Please ask for: Ms Iqraa Malik
Email: iqraa.malik@terraquest.co.uk
Telephone: 0121 234 1390
Our Ref: AL/46/22/HH
Your Ref:
Date: 6th April 2022

Application for Planning Permission for Works or Extension to a Dwelling

Development: Erection of single storey rear extension and conversion of loft to habitable use including the installation of 1 x rear dormer with juliette balcony and 2 x front rooflights.

Location: 45 Ivy Lane Westergate Aldingbourne PO20 3RE

Block Plan
Scale 1:500

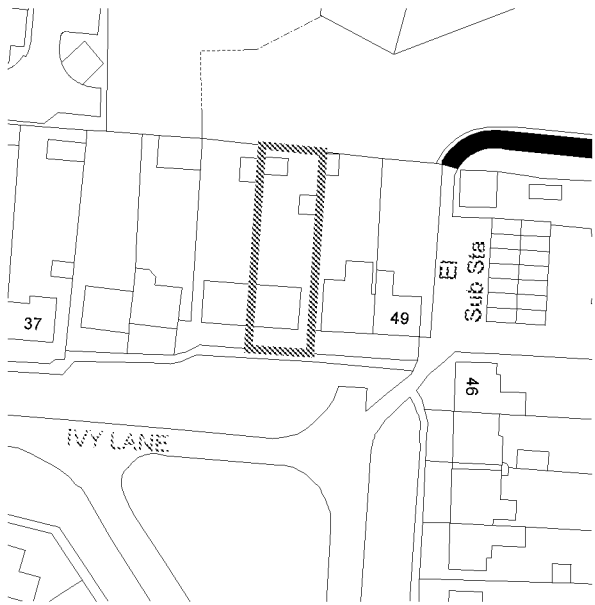
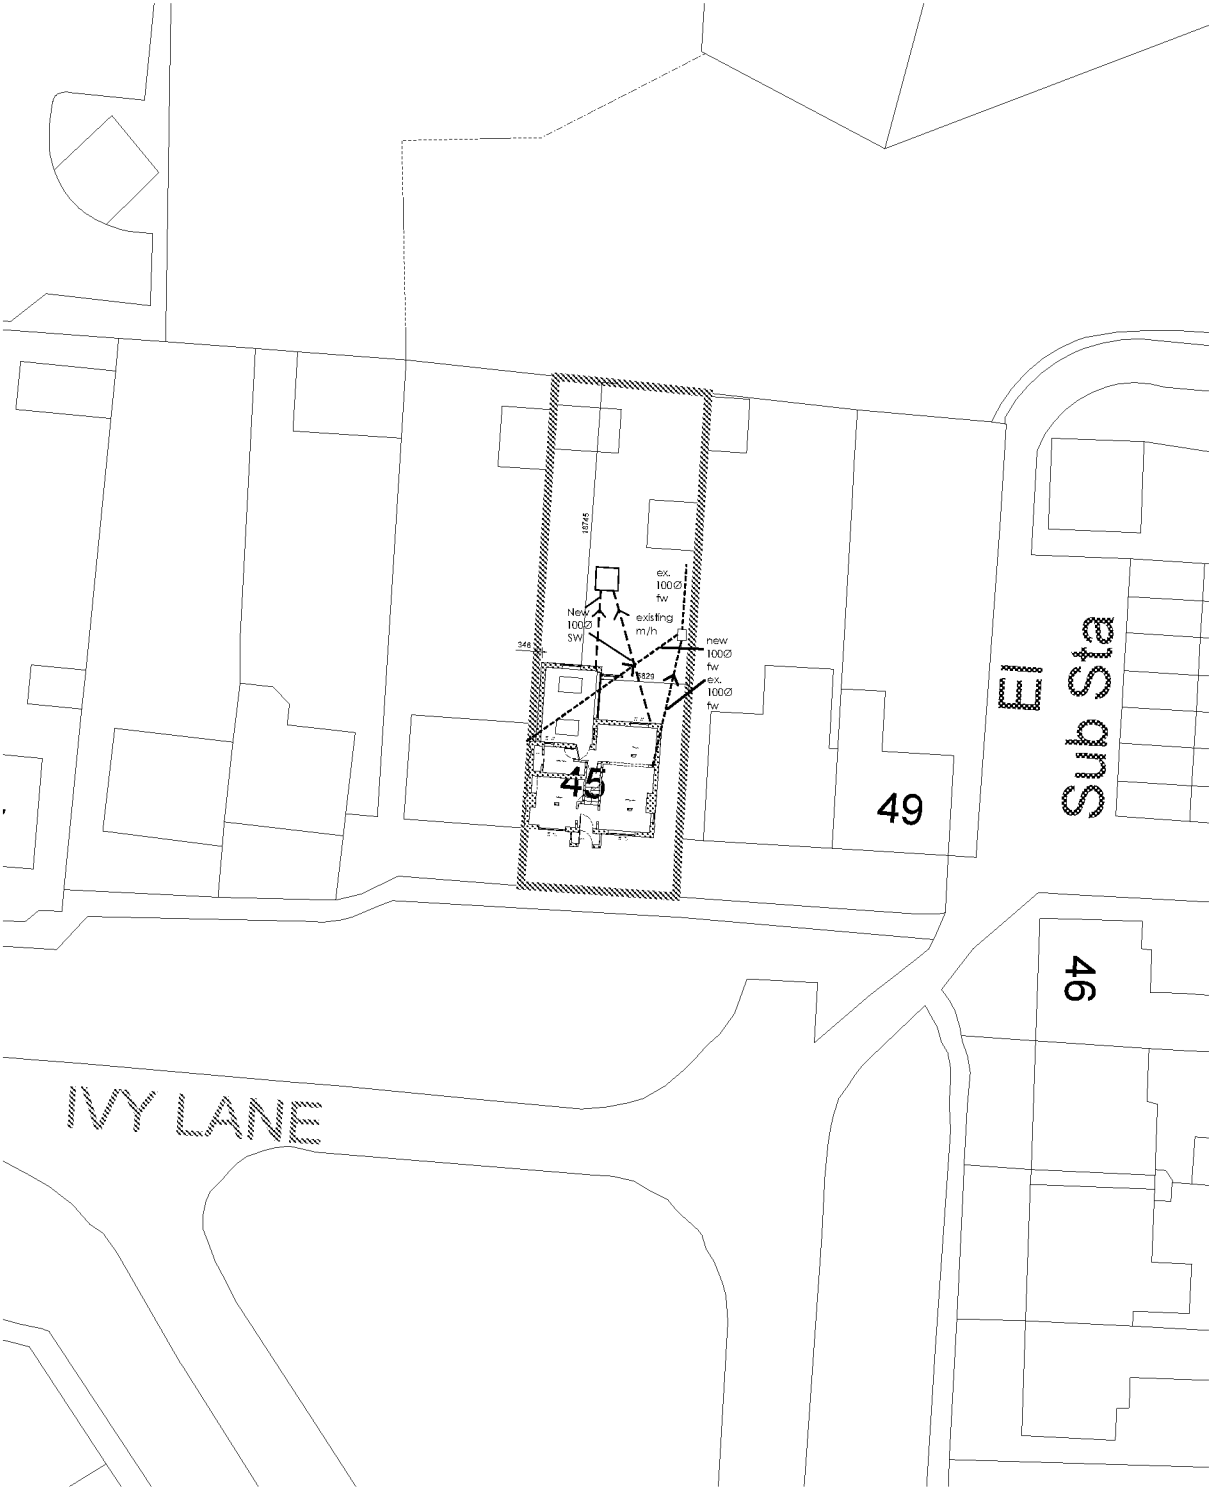
You are required to have dimensions from the proposed extension(s) to all site boundaries. Please amend.
